Our reference: ECM Ref: 9696081  
Contact: Gavin Cherry  
Telephone: (02) 4732 8125

30 August 2021

**Response to Request for Advice: SSD-7348-Mod-7 Oakdale West Estate  
Modification 7 at 2 Aldington Road, Kemps Creek**

Figure 1 – Precinct 3 – Modification No. 7 earthworks compared to Approved Modification No. 6

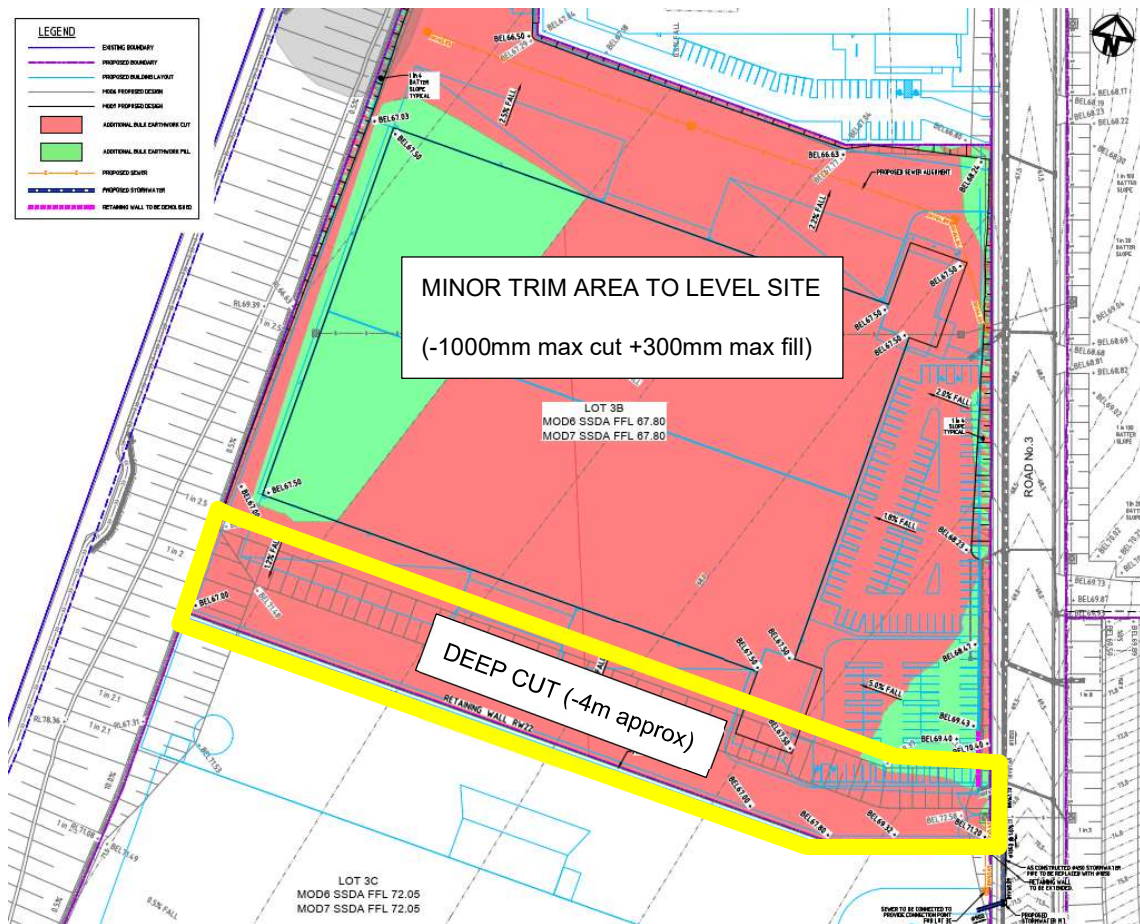
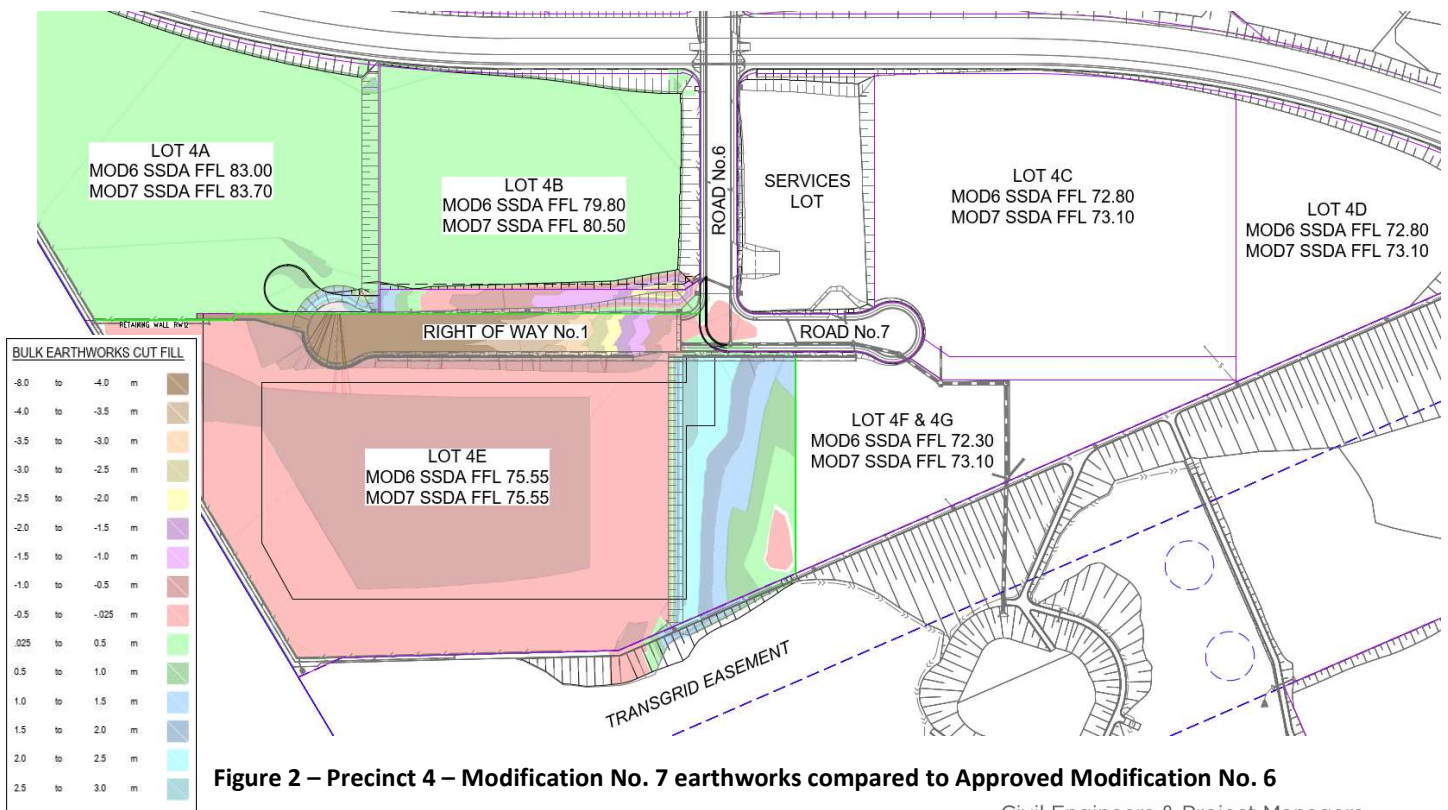
- The appropriateness of the proposed increased finished ground levels with respect to adjacent properties. The SEE makes reference to a maximum of 700mm which is believed to be up to 800mm of additional fill. The resulting interface treatment at the boundaries of the estate should be carefully considered.
- The proposal indicates additional filling works within the transmission easement. Referral to and agreement from the relevant authority (assumed to be Transgrid) is considered necessary to ensure that the fill and amended finished ground levels will not impede access to and maintenance of the infrastructure

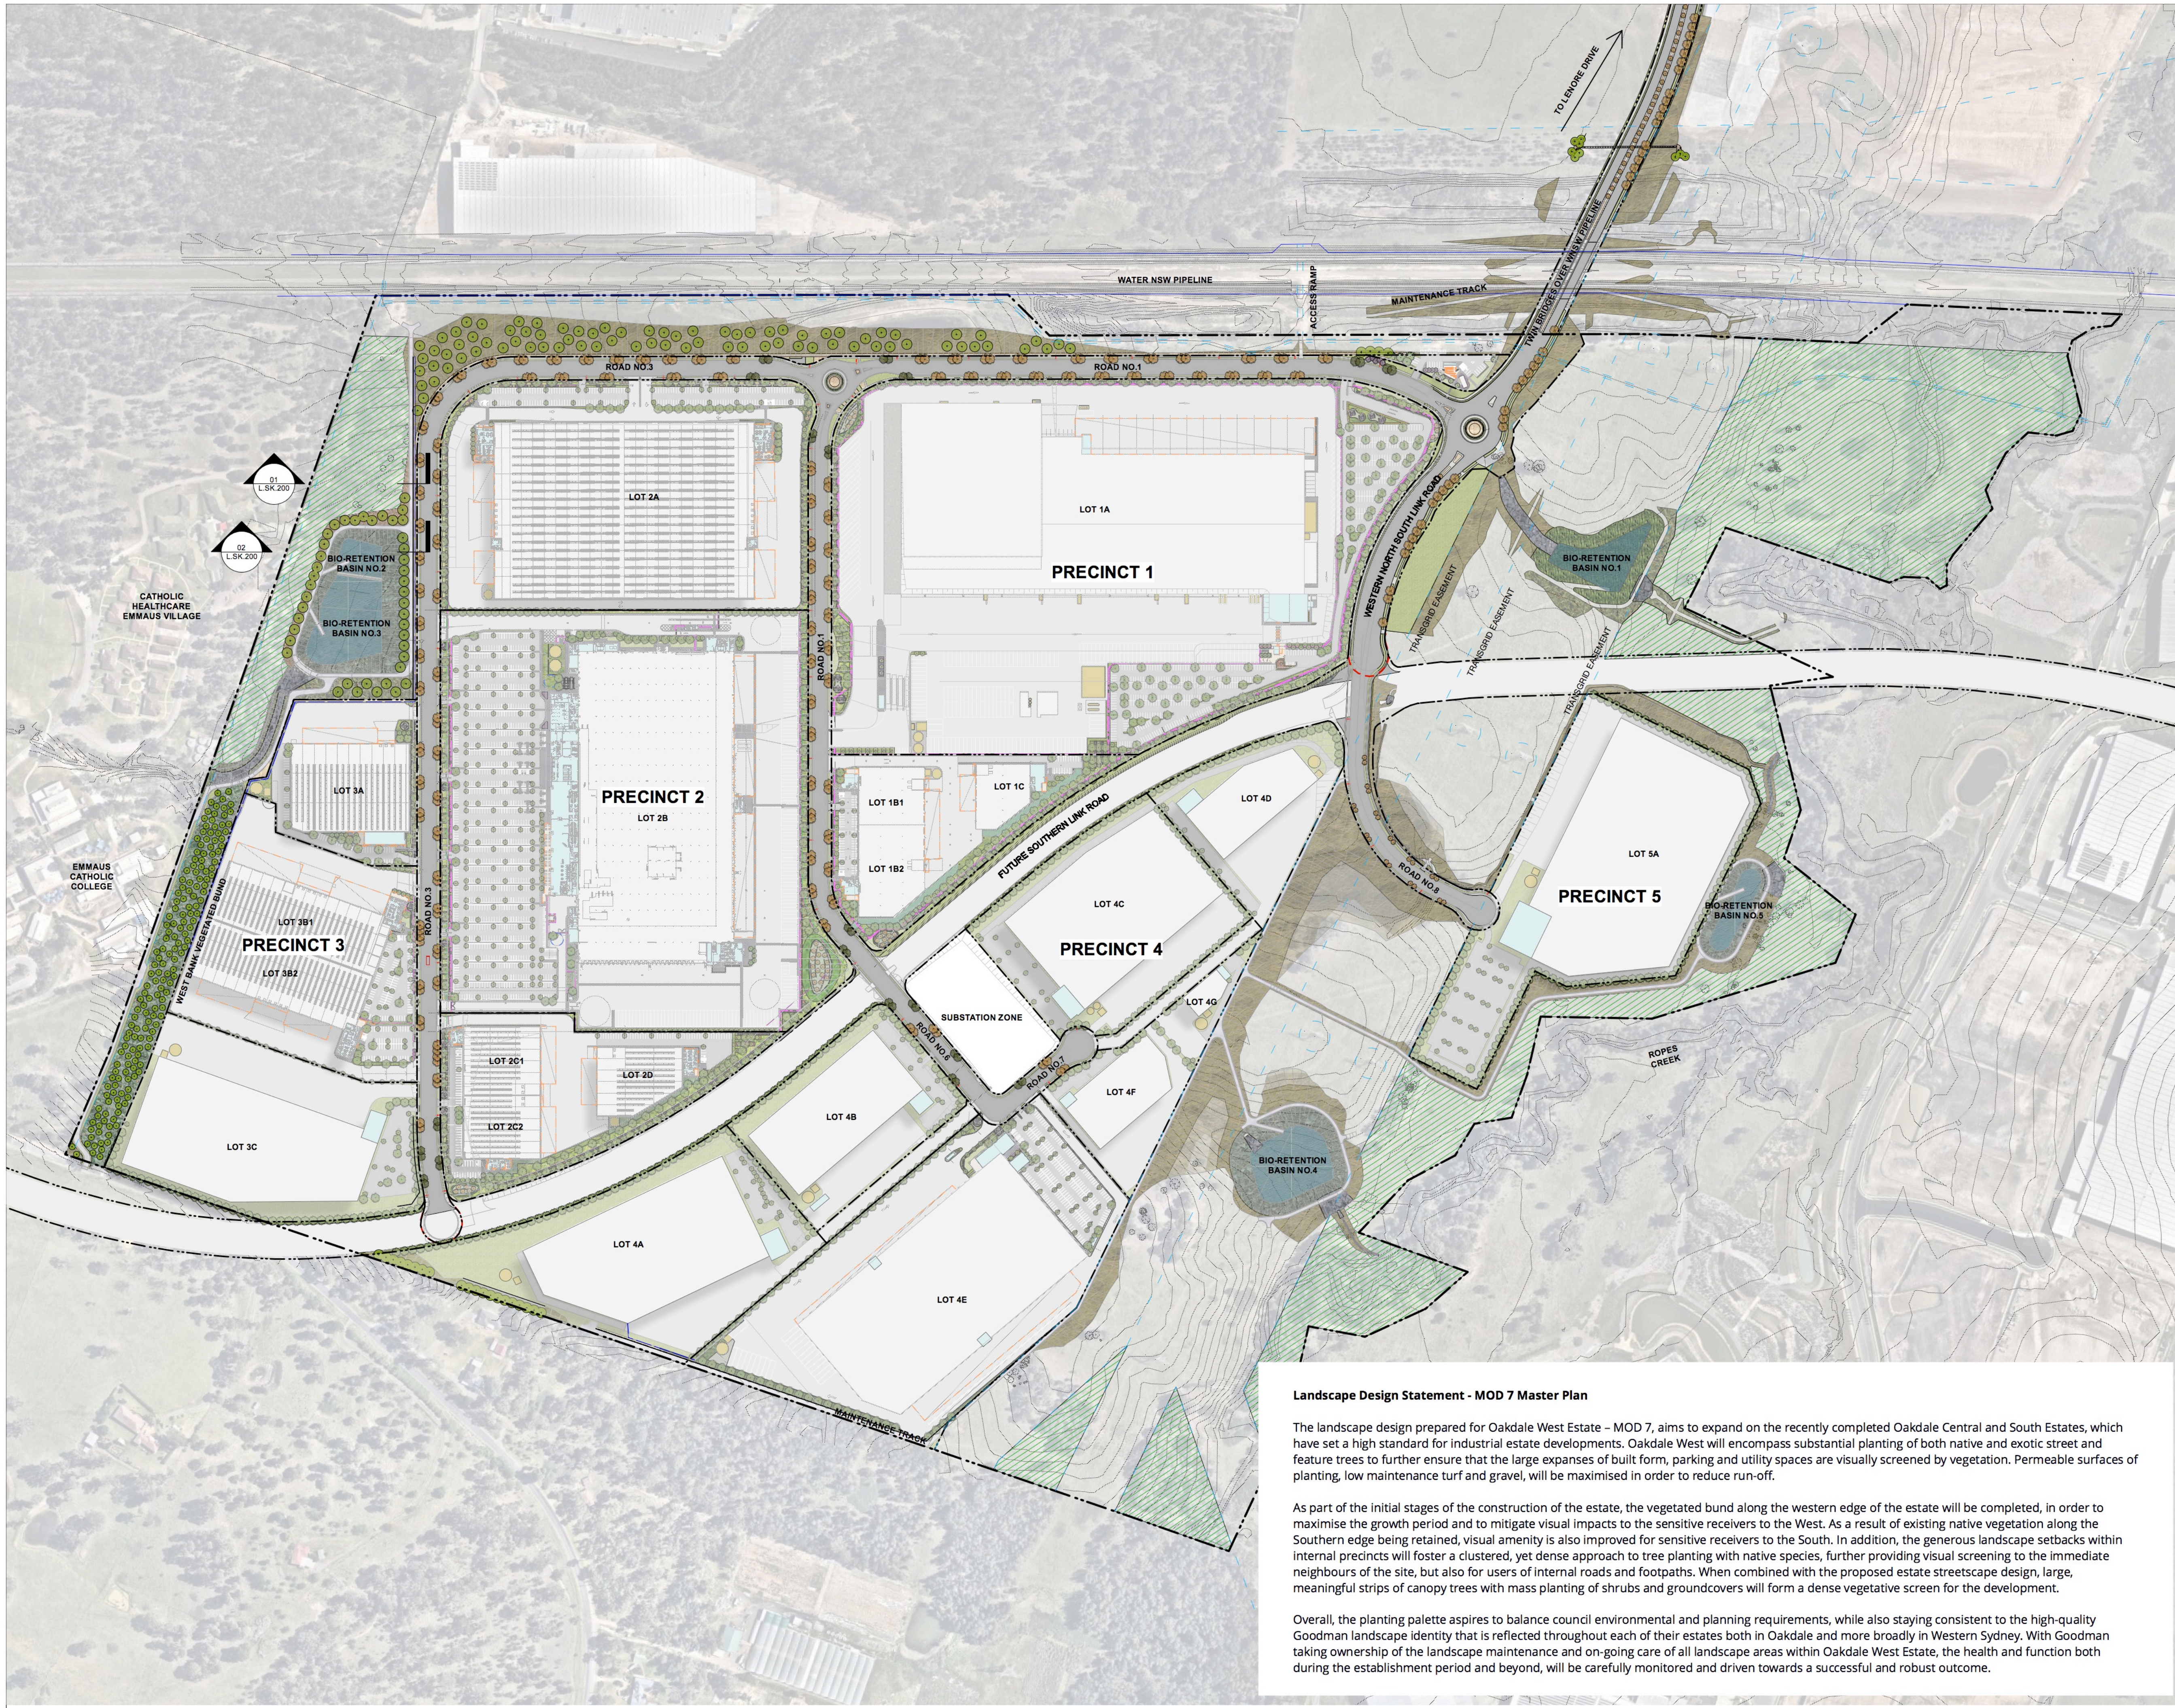
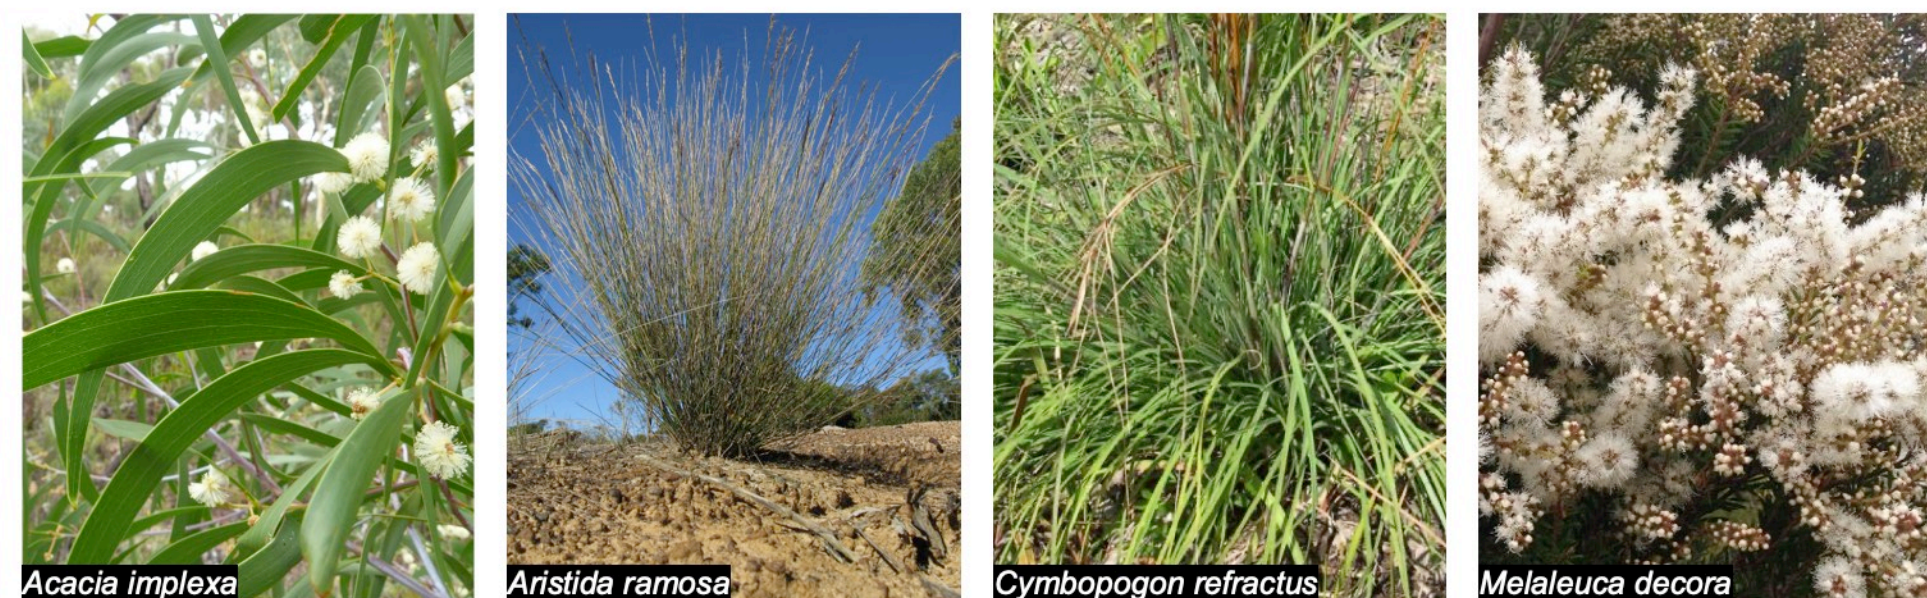
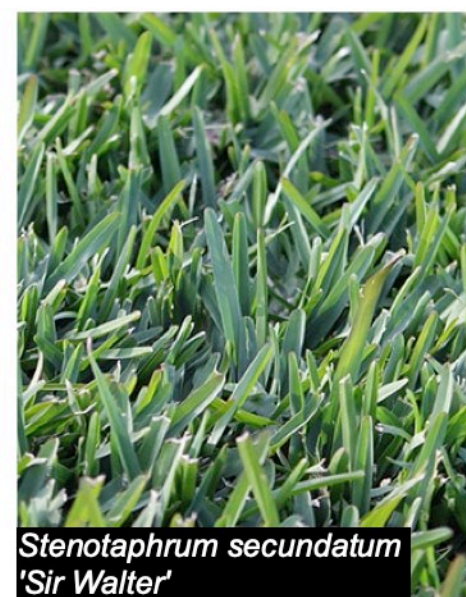
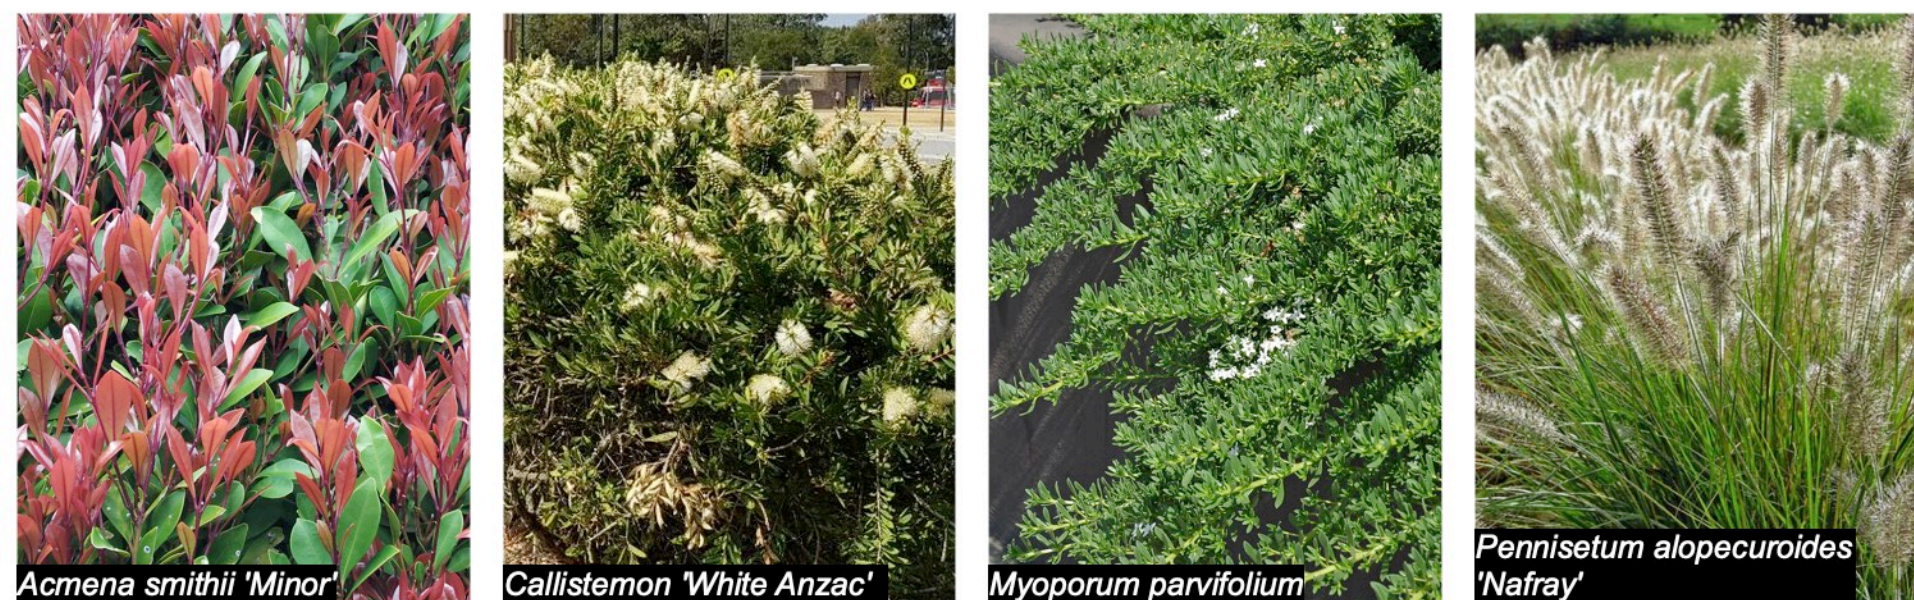
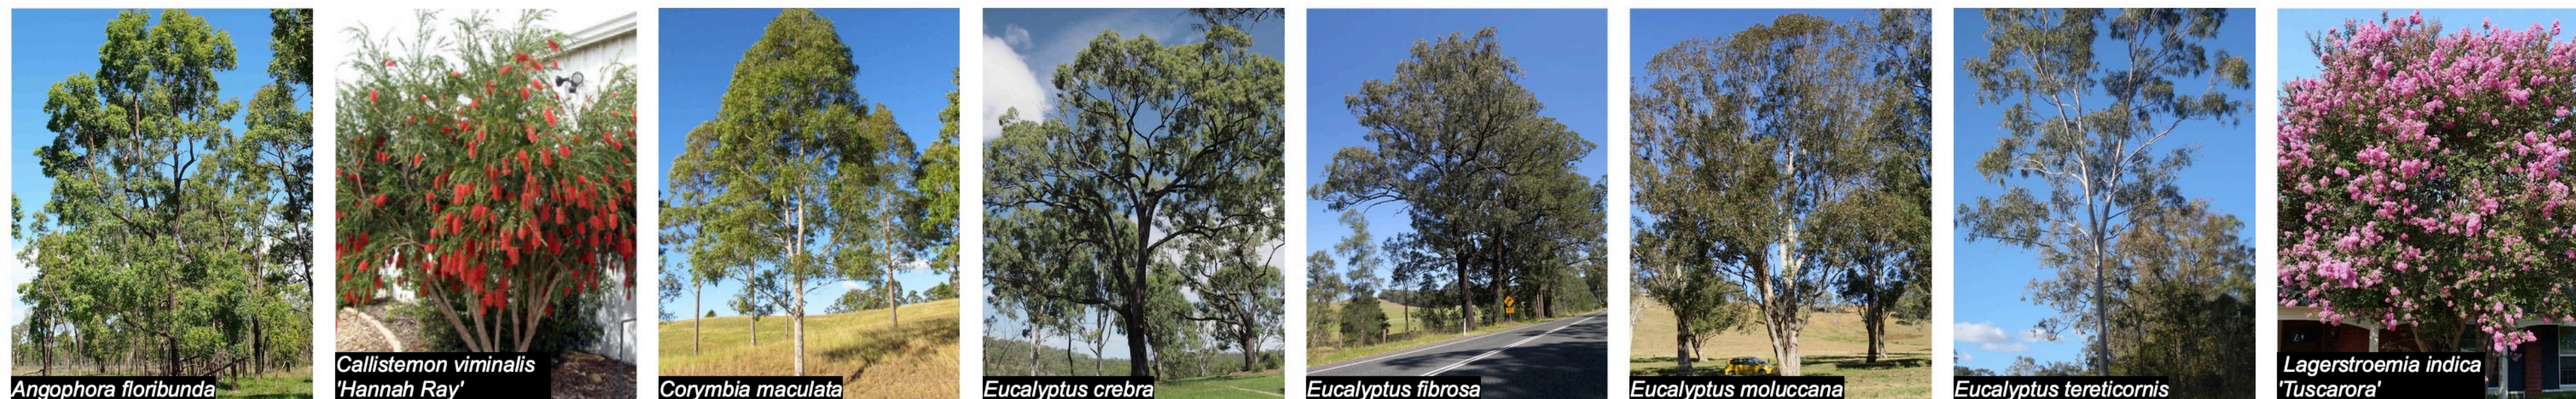
- The final sheet (L.SK.200 – landscape sections) in the landscape set of drawings was not available and is requested to be provided to Council for consideration.
- As has been requested in preceding stages, continuous canopy street tree plantings in organic mulch is required for maximum shade and cooling to satisfy Council's Cooling the Cities Strategy and NSW Greener Places Guide. The spatial arrangement of street tree planting is

inadequate, as continues to be indicated in the concept plans submitted within each stage. Additional infill planting between excessively spaced street tree groupings is required to ensure continuous canopy or layering of canopy planting within the verge as well as within the street setback zones.

- Shrubs and groundcovers are not acceptable in street verges as they compromise visibility and safety. They would not be maintained by Council. This is standard practice for Penrith City Council verges and the plans must be amended accordingly.

- Street tree species are to be amended – the following species are oversized for the width of verge and in time will compromise and damage adjacent infrastructure: *E. tereticornis*, *E. punctata*, *E. moluccana*, *E. fibrosa*, *A. floribunda*, *E. crebra*. Tree species are to be appropriate for the location and site conditions (available rootzone volume, soils, microclimate etc). Alternative species are required. A diverse mix of species is supported for increased biodiversity, resilience, wayfinding and amenity. The applicant is encouraged to liaise with Council's Assets Team for tree species advice. Maximum mature height of 15m is recommended. Alternatively conditions of consent could be included requiring agreement from Council on the selection of street tree planting species to be utilized.

- Street trees should be planted as individual trees in mulched areas and spaced apart so that mature canopies touch. As a result, there will be a continuous canopy in the street. Adjust spacings to suit overhead street lighting and driveways.

- Unless required as a result of bushfire hazard assessment, groundcovers and shrubs should be planted on embankments for biodiversity and screening eg. Northern boundary embankment which is currently shown as only native grasses under trees.
